From: Miller, Michael [REDACTED]
Sent: 18 December 2020 12:53
To: A1 in Northumberland: Morpeth to Ellingham
<A1inNorthumberland@planninginspectorate.gov.uk>
Cc: Courage, Cara [REDACTED] Cussen, Bob
<[REDACTED]> Whitehead, Andrew
<[REDACTED]>
Subject: A1 Northumberland. Morpeth- Ellingham Part B Examination representation.

I write on behalf of Natural England following recent discussion regarding changes to the proposed scheme within Part B of the A1 upgrades in Northumberland.

Our main concerns relate to the proposed changes relating to the in the bridge design set out in Highways England's document titled A1 in Northumberland: Morpeth to Ellingham, Scheme No. TR010059 – Summary of Proposed Changes to Application. Natural England's main concerns relate to the following design changes:

Permanent Works at the River Coquet

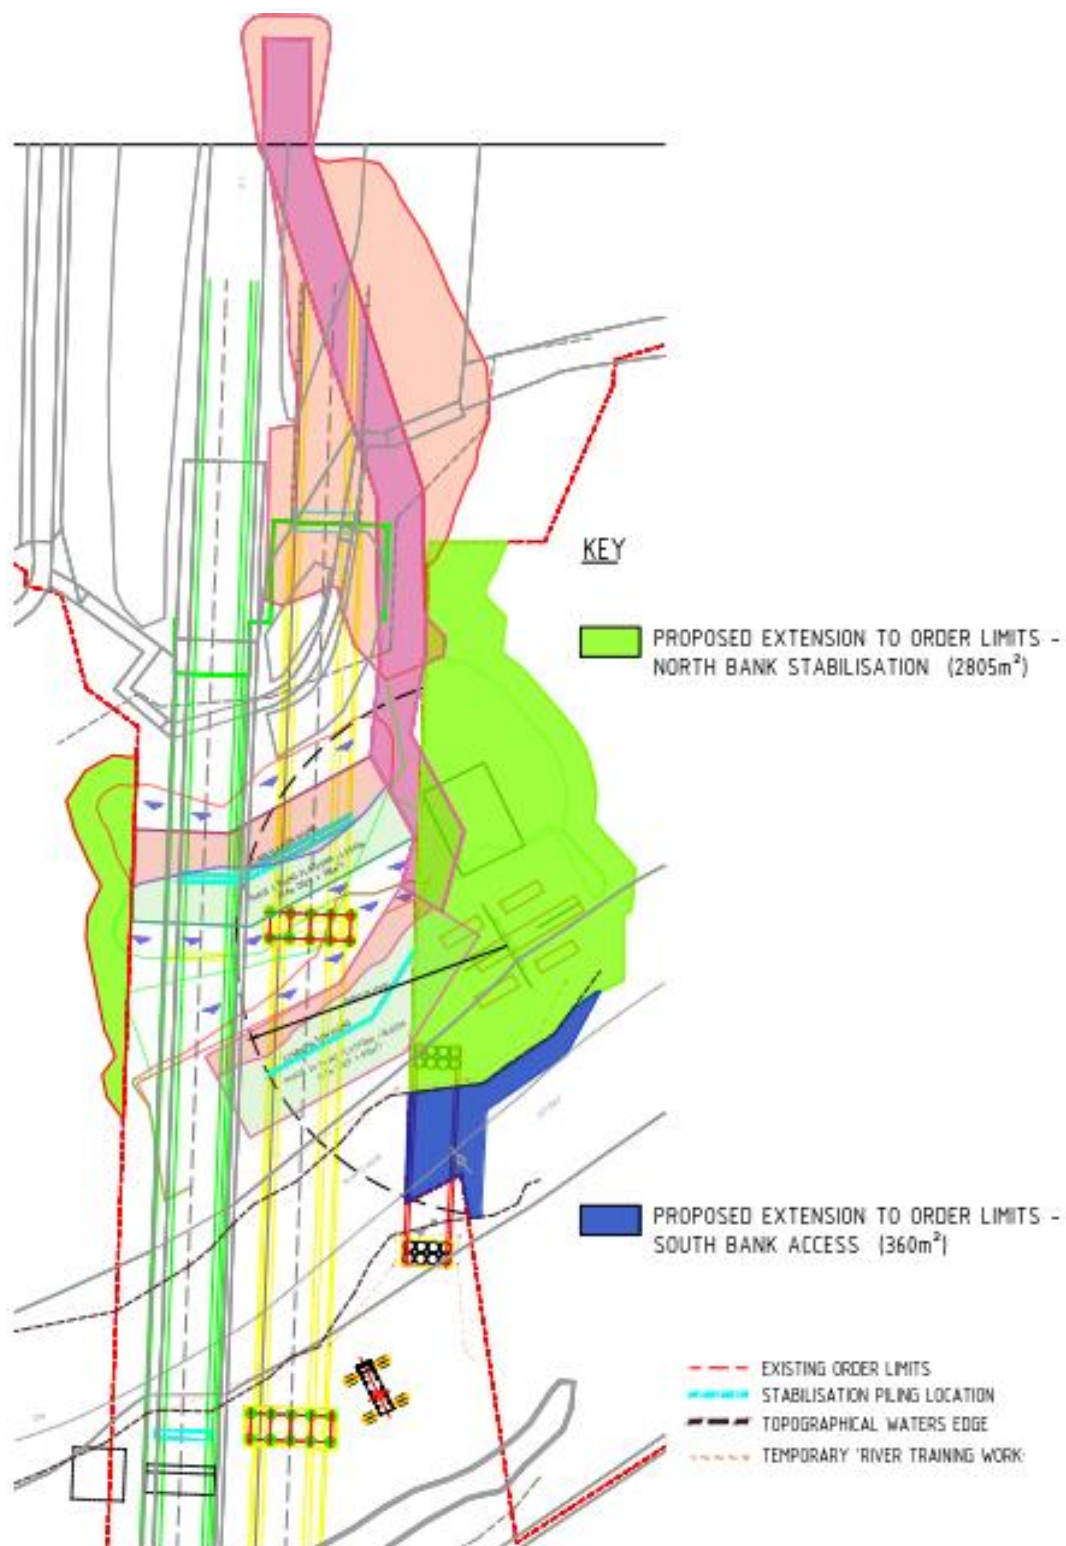
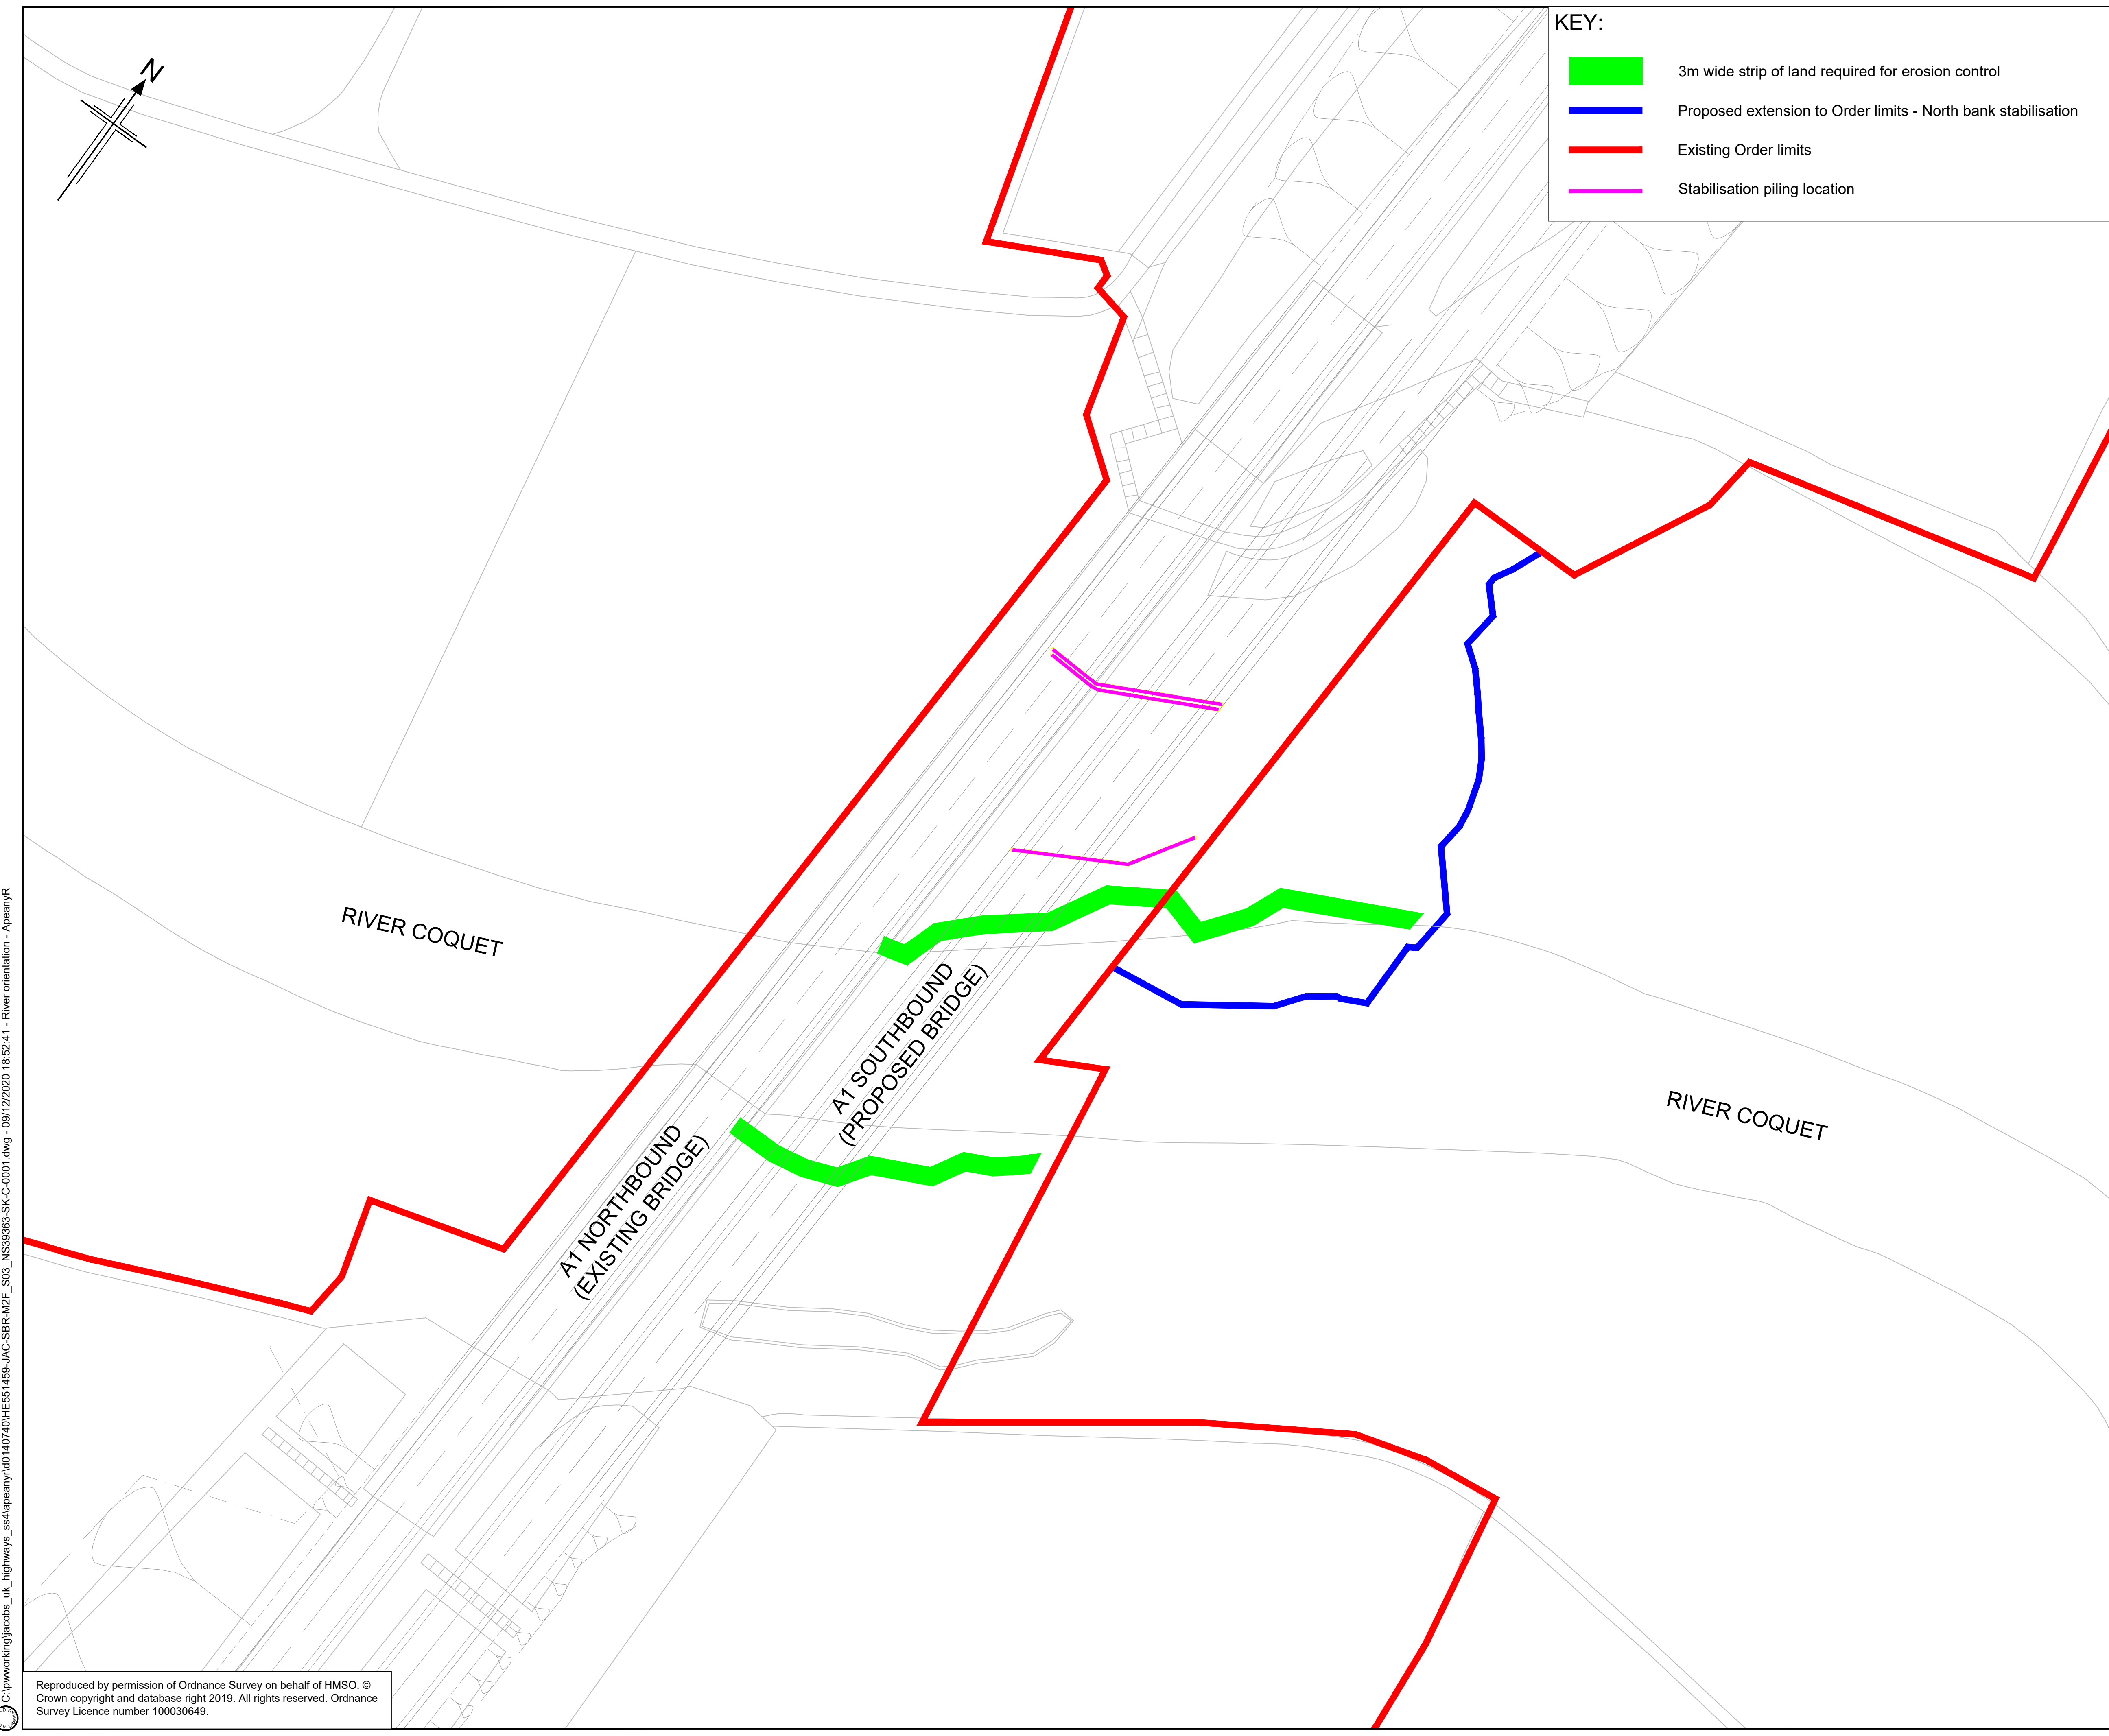
- Alteration of the location of the southern pier of the bridge potentially move it 2m closer to the river's edge which will increase the structures impact on flow dynamics during high flow events.
- The addition of a considerable length of bank protection (possibly rock armour although other solutions will be looked at) on the north bank of the river to address the risk of fluvial erosion and instability of the sloping land north of the riverbank.
- The addition of rock armour on the southern bank of the river for erosion control purposes where it is not clear where any significant erosion exists.
- Use of river training and a temporary bridge from the north to the south side of the river for approximately 15 months.

Natural England's main concerns relate to both the permanent loss of riverbank associated with the proposed areas of rock armouring and the impacts that this may have on the fluvial geomorphology of this relatively unmodified section of the river. All of the proposed works fall within the River Coquet and Coquet Valley Woodlands SSSI which is notified for both woodland and river interest features, the latter of which cover both the form and function of the bed and banks of the river. As the proposed permanent use of bank protection on this reach would destroy/severely damage the bank habitat and geomorphological process, the loss of these elements of the sites interest features would require suitable compensation elsewhere on the river system.

While the use of the temporary bridge (last bullet point above) will negatively impact on the SSSI, Natural England accepts that the impacts of this will largely be temporary in nature and we acknowledge that it's use would potentially reduce the need for a larger permanent foot print on the south bank of the river. Overall we concur this would result in a reduction of works required within the ancient and semi-natural woodland interest feature of the SSSI on the south side of the river.

In conclusion, Natural England are of the opinion that these changes to the crossing over the river constitute significant changes to the scheme which have the potential to have significant impacts on the designated sites at the River Coquet.
